Recommendation Report for Planning Permission for Works or Extension to a Dwelling

REF NO: FP/275/21/HH

LOCATION: Ciel  
The Ridgway  
Felpham  
PO22 7JQ

PROPOSAL: Erection of single storey rear extension including the installation of roof lanterns following the demolition of existing conservatory.

Proposed East Elevation
1 : 100

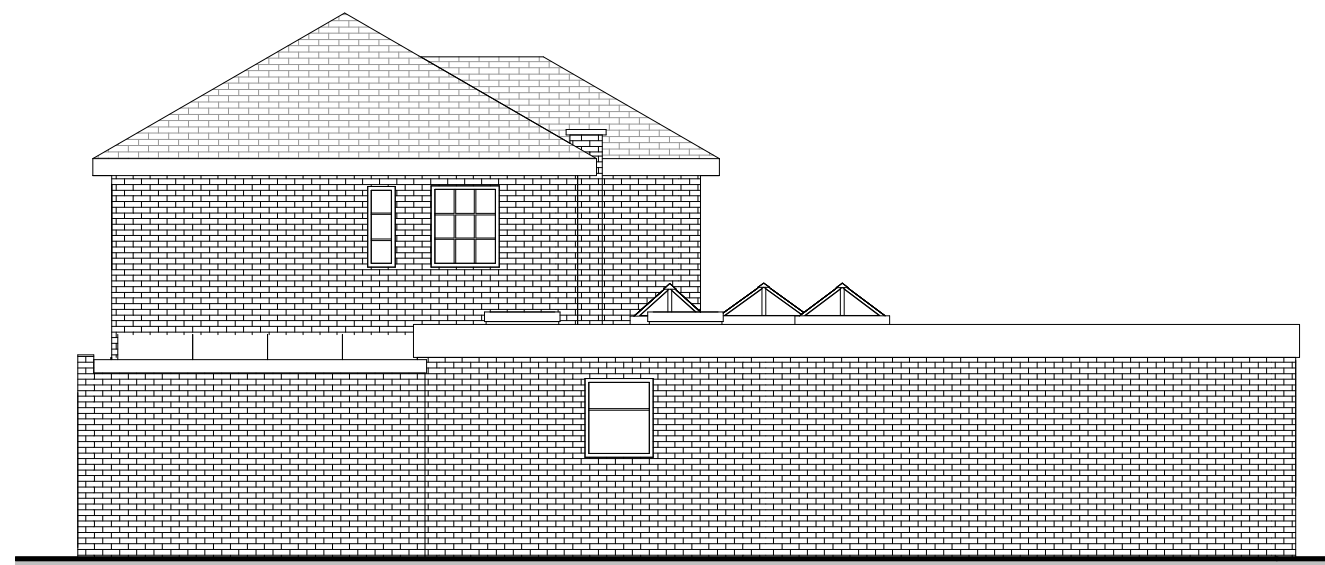
At present, there is a conservatory to the rear of the property. The extension will replace this, extending slightly further west than the existing footings, with a depth of 7m and width of 3.84m. It will have a flat roof, which will join to and match the design of an existing rear extension. This will differ to the hipped roof of the main dwelling, but will integrate well with the existing extension and have minimal harm on the visual appearance and character of the property. The Ridgway has a mixed composition, with the majority of properties being detached two storeys, all exhibiting a variety of design styles. The proposal is in keeping with the character of the property, and with that of the neighbouring properties in the locality. Although being to the rear, the proposal protrudes slightly higher than the existing front garage, and will be partially visible from the street scene. This visibility is minimal and insignificant, and will have no adverse impact on the composition or appearance of the street.

The proposal is single storey and will have a flat roof, joining up with an existing extension. This roof has a height of approximately 3.09m. The proposal includes the installation of three sky lanterns and two flat rooflights. The lanterns will protrude slightly above the roof, at a height of approximately 3.63m but will

not be unacceptably overbearing. A distance of 1.273m to the north, 6.33m to the west and 10.403m to the south boundaries will be retained. The Arun Design Guide recommends the use of the 45 degree rule for rear extensions, in order to work out impact on neighbouring properties. The proposal meets this rule, and given its scale, is not considered to be unduly overbearing or overshadowing of neighbouring properties. It retains more than 1m from the closest neighbouring boundary, and will have no adverse impact on residential amenity. This is in accord with D DM4.

The proposal allows for a new games room, and will include the installation of a new bathroom in the utility room. It will feature a window to the furthest western elevation, set of glass doors to the south and new door to the west elevation of the existing extension. It will include five rooflights, all of which will have no adverse impact on residential amenity. The features to the west will result in little overlooking of neighbouring properties, as they are a significant distance from the neighbouring properties to the rear, and are separated by a tennis court. The doors to the south face towards the rear garden of No.23, and risk potential overlooking. Given their height and proximity from the boundary, they are not considered to be unduly harmful to neighbouring privacy and amenity, and are acceptable.

Proposed Ground Floor
1 : 100

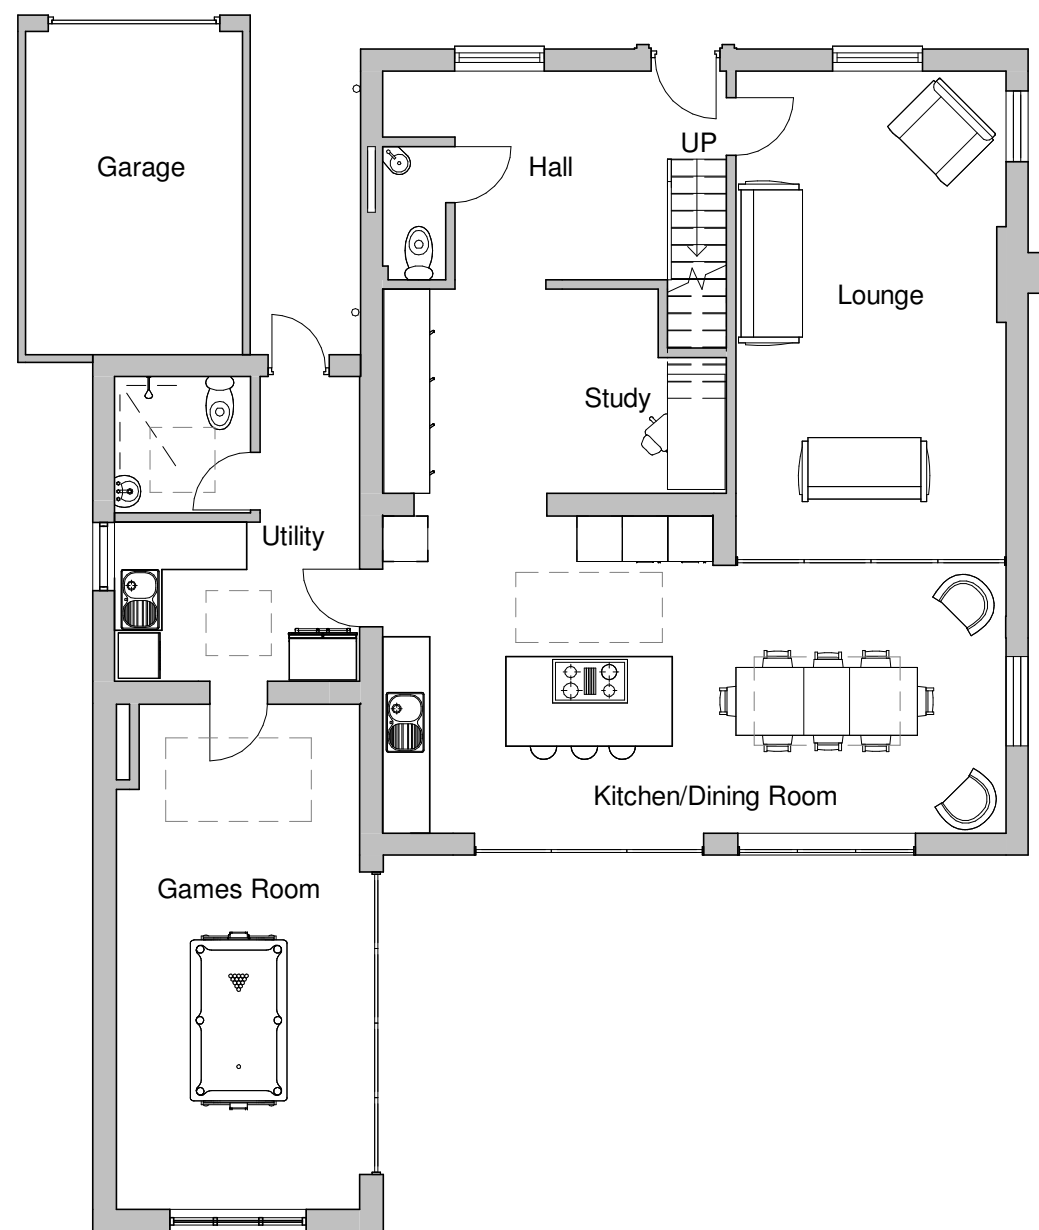
The proposal will include the removal of one tree (T1) which is situated to the north, between the proposal and the neighbouring boundary. The site is covered by a TPO (Bognor No.5), but T1 itself is not covered by an individual order, nor is in a conservation area or a significant contribution to the area. Therefore, the loss of this tree is acceptable for the development of the proposed works.
